Please ask for: Sian Eggington
Email: sian.eggington@terraquest.co.uk
Telephone: 0121 2341390
Our Ref: LU/217/20/HH
Your Ref:
Date: 19th August 2020

Application for Planning Permission for Works or Extension to a Dwelling

Development: Rear Extension & Outbuilding
Location: 34 Pier Road Littlehampton BN17 5LW

Landscape drawing - Out building Office

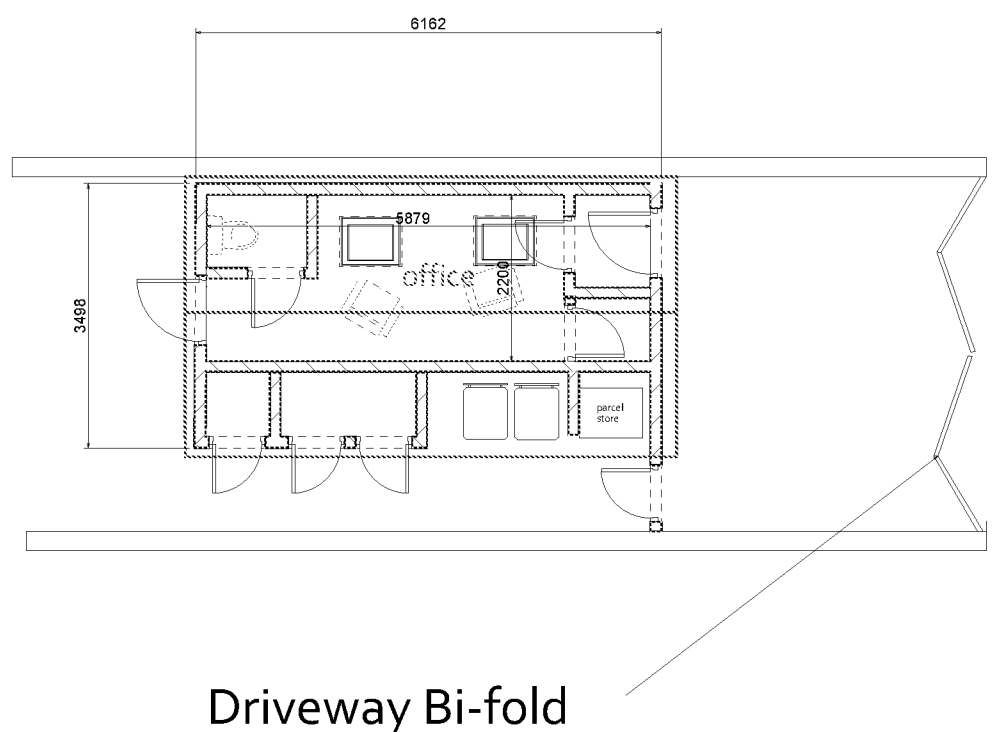
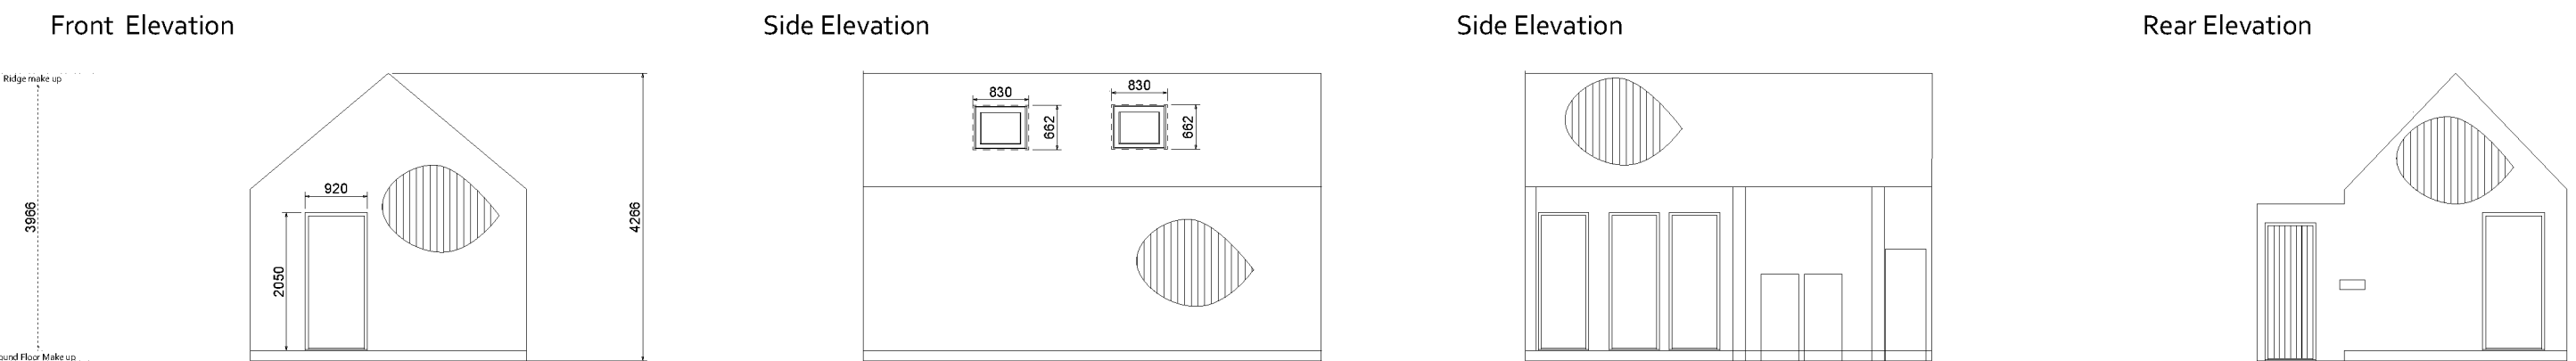
Outbuilding: Please submit the proposed floor plans and elevations for the outbuilding
